Great Wolf Lodge, Chesterton, Bicester
Great Lakes UK Limited

Design & Access Statement Addendum

December 2021

This document has been prepared by EPR Architects in collaboration with the wider design team, to be read as an addendum to the original 2019 application (Application Ref. 19/02550/F (Appeal Ref: APP/C3105/W/20/3259189)).

Proposed Ground Floor Plan Part 10

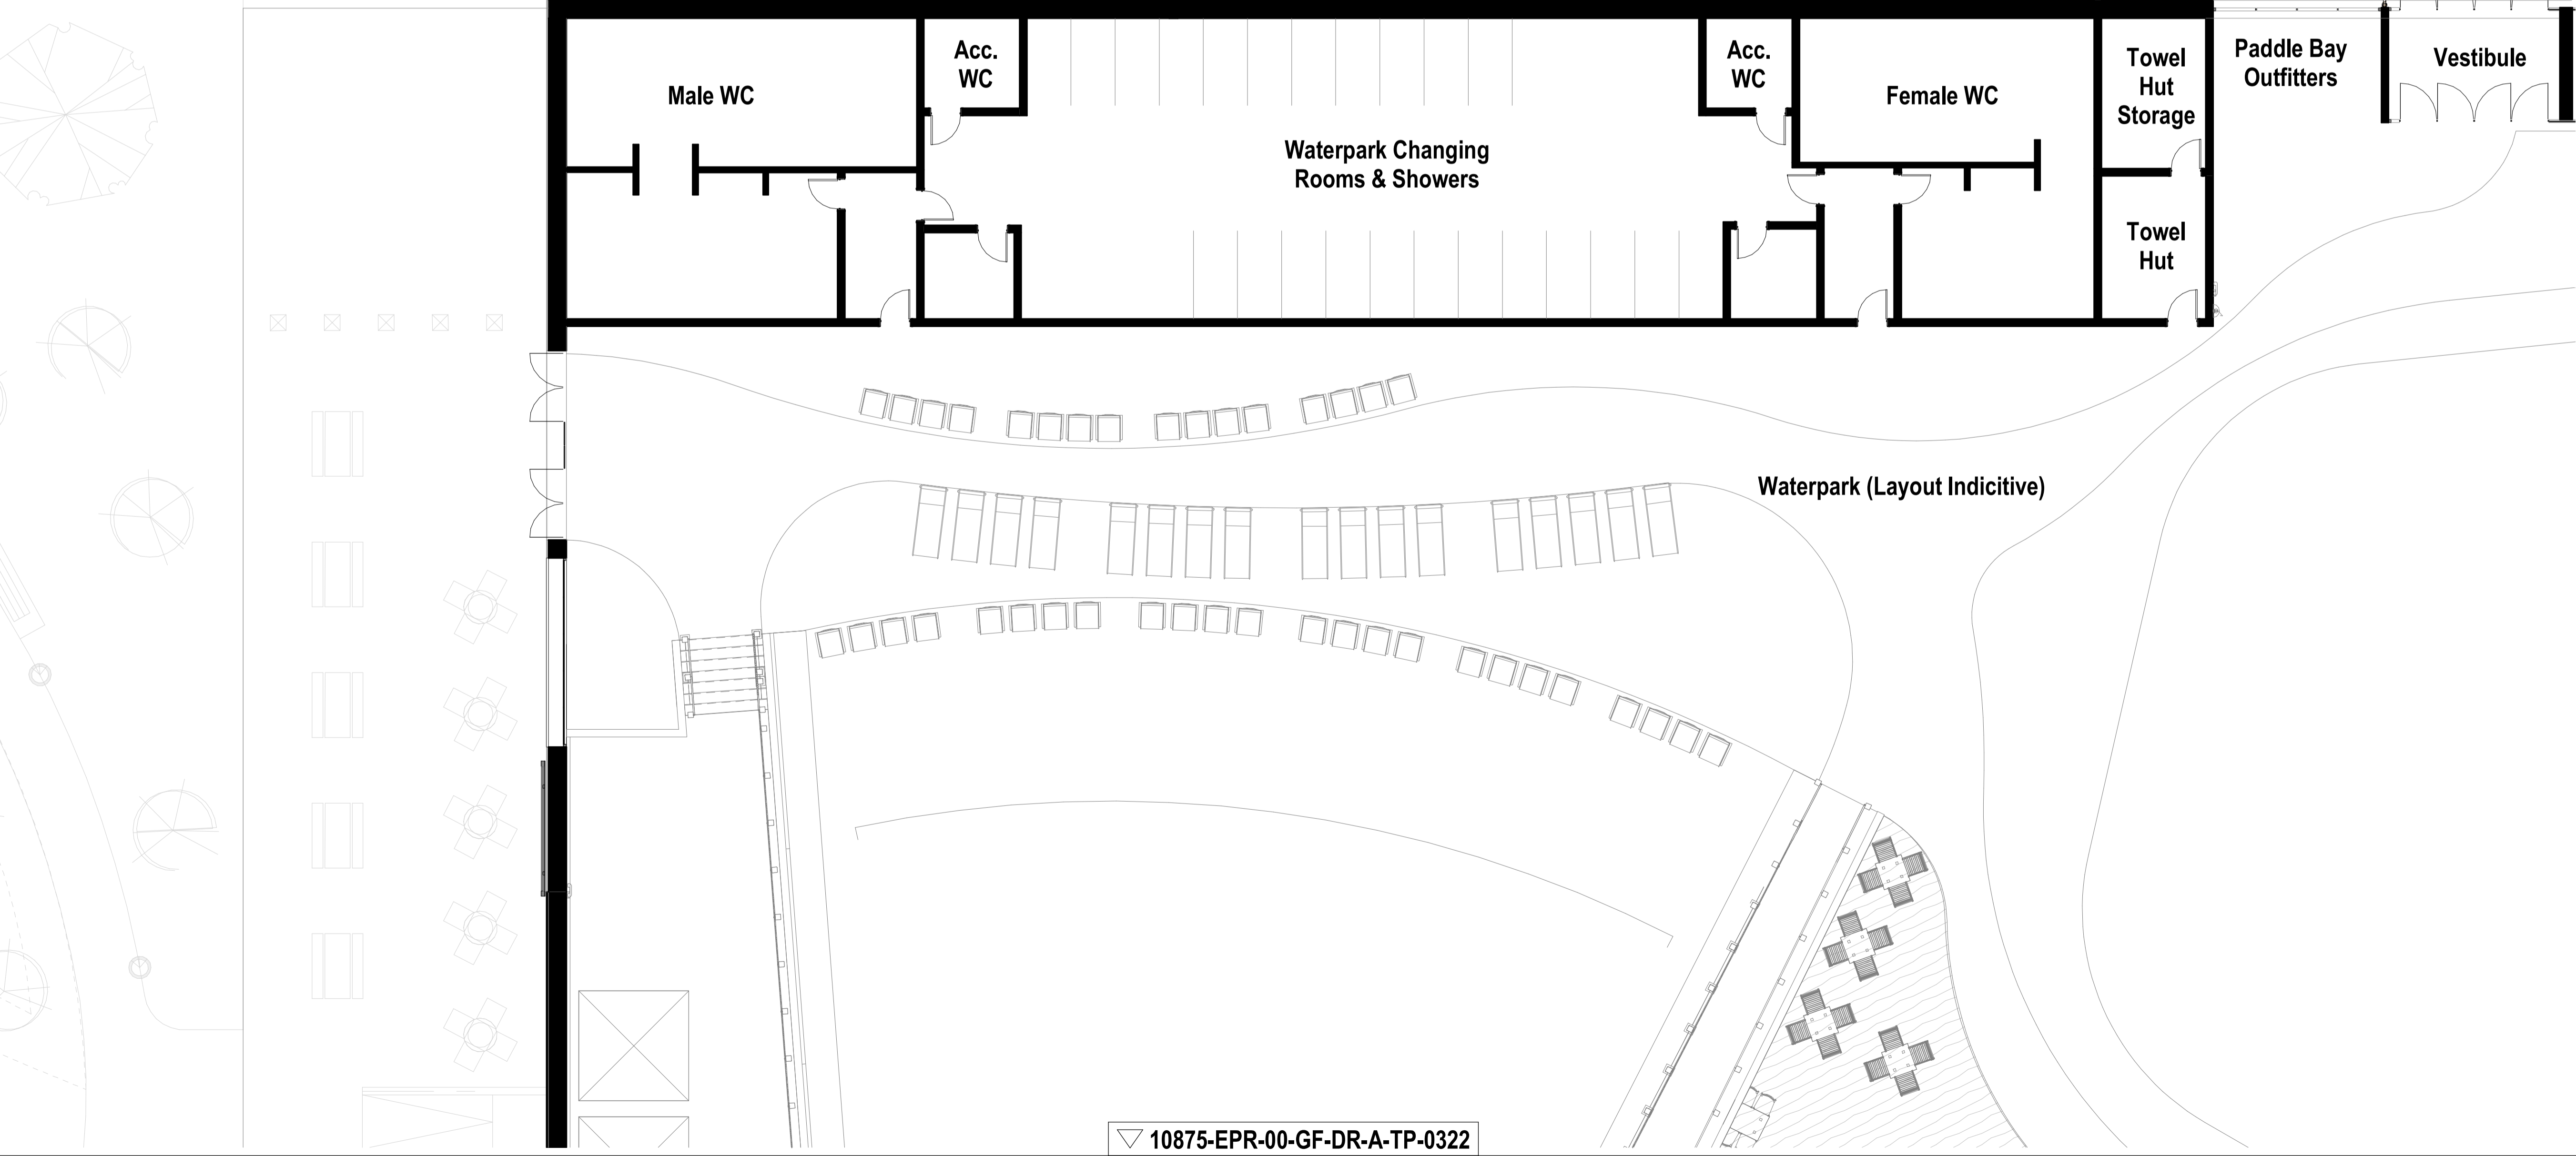
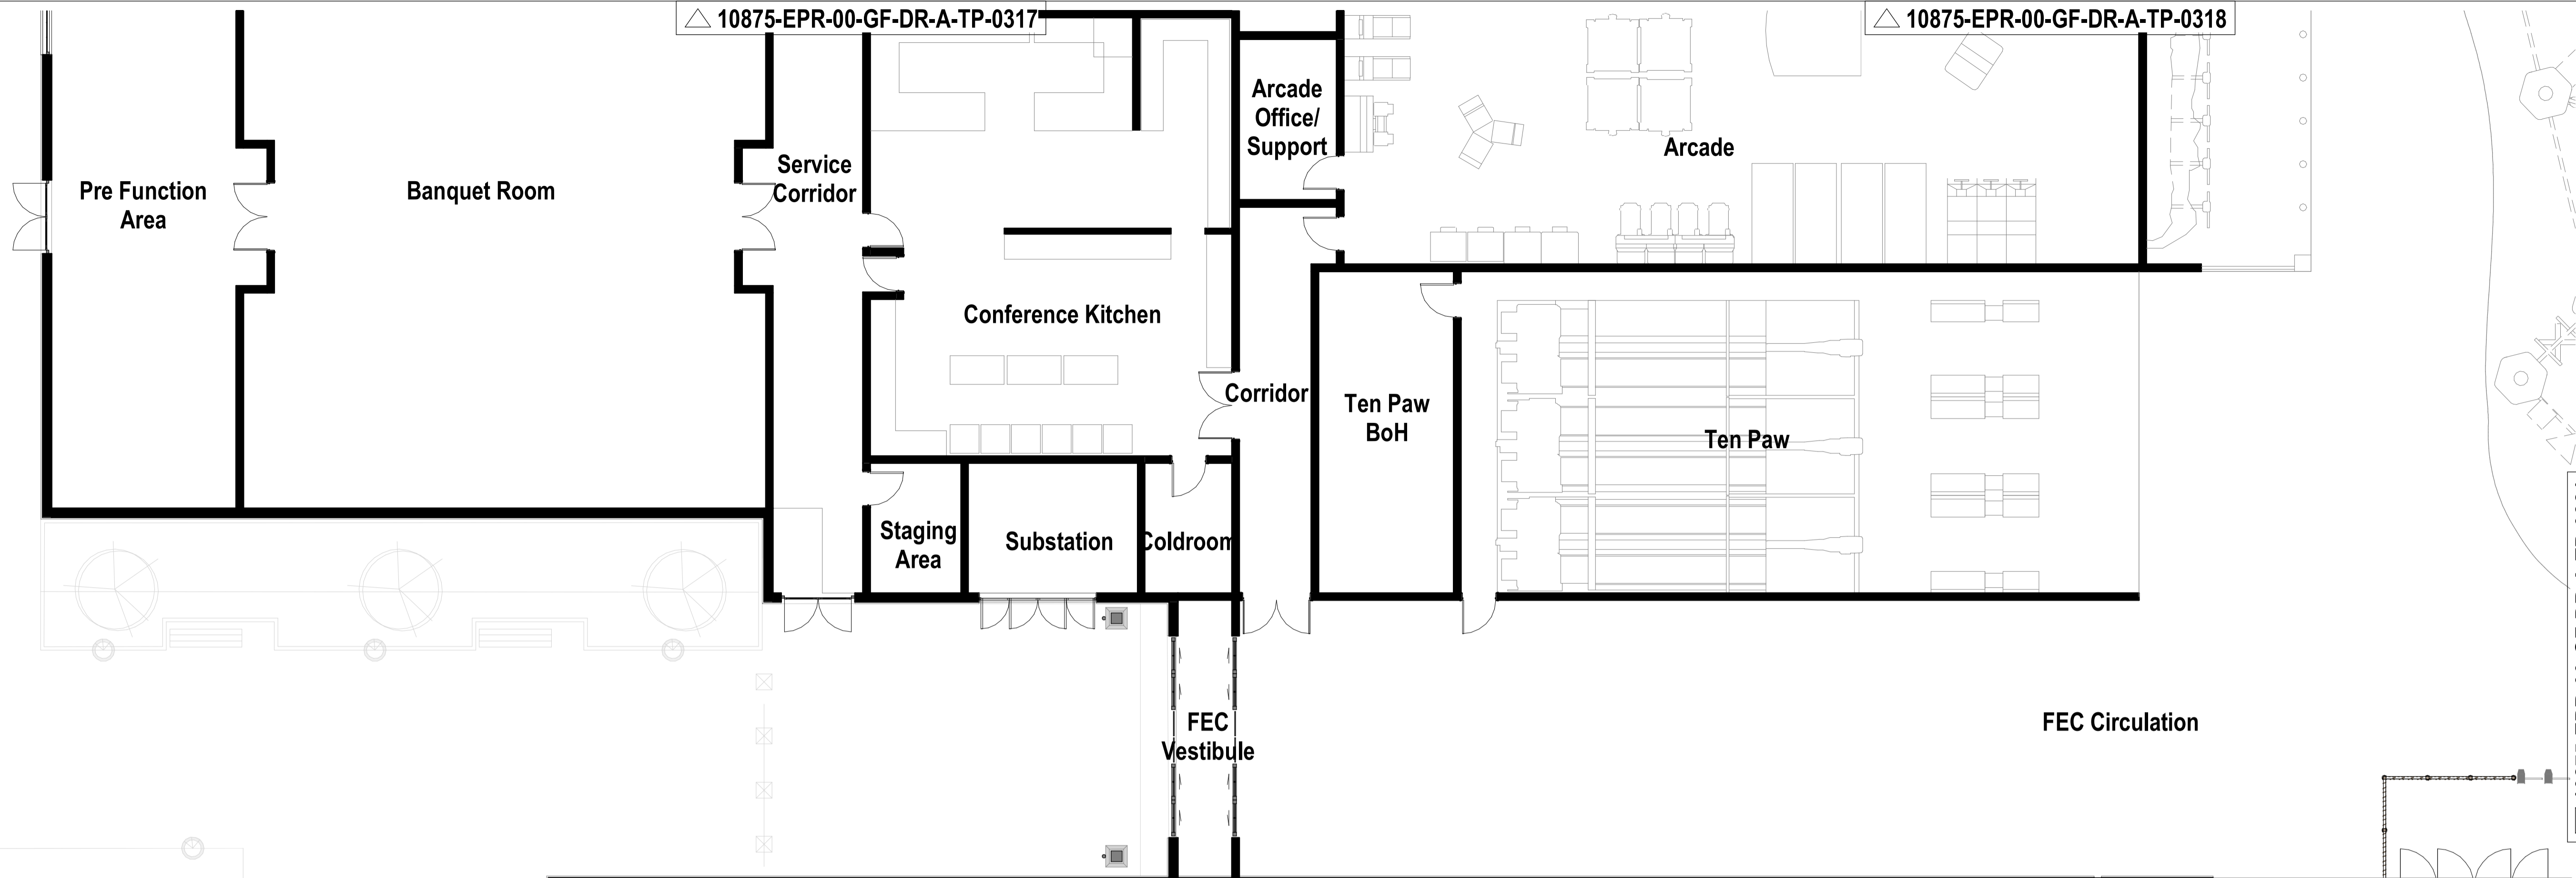
1. Reduction in the overall size of the FEC resulting in a shift of the guestroom u-shaped tower southwards by approx. 3.6m.
2. Updates to the landscape design proposal as a result of the building footprint changes and reconfiguration of the Conference centre and fire tender access to the site. I.e. Conference centre road split off from the perimeter access road moved in line with revised conference centre design.

3. Extension of the Porte cochere as a result of shifting the building southwards 3.6m. Updates made to create a larger drop off/set down point for arriving guest vehicles and shuttle buses. Refer to page 13 for details.

4. Re-configuration of the conference centre massing, facade design and internal layout.
5. External water park deck layouts revised and height levels updated to facilitate raised terrace zone with associated balustrade. Enlargened square to the South East corner created to host new outdoor whirlpool design.

6. External exposed Co2 storage tank to be located outside the proposed bunker building. Storage tank to be sat on a concrete plinth with perimeter bollards.

7. Waste yard loading bay ramp shifted 500mm closer to building envelope and concrete vehicular guarding added. Ramp increased in length.
